From: wilpshire parish council <wilpshireparishcouncil@gmail.com>

Subject: Comments on planning application consultations

Consultation on planning application 3/2021/1054 23 Whalley Road, Wilpshire BB1 9LQ Proposed change of use and exterior alterations of a former photography studio (Use Class E) to three flats (Use class C3) and associated infrastructure.

PROPOSED BLOCK SITE PLAN
1:200@A3

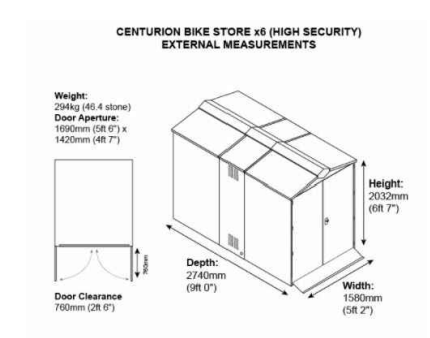
Wilpshire Parish Council support this application, in so far as, it is making use of a neglected building but have concerns about parking and the size of parking spaces so that the pavement is not obstructed when vehicles are parked there.
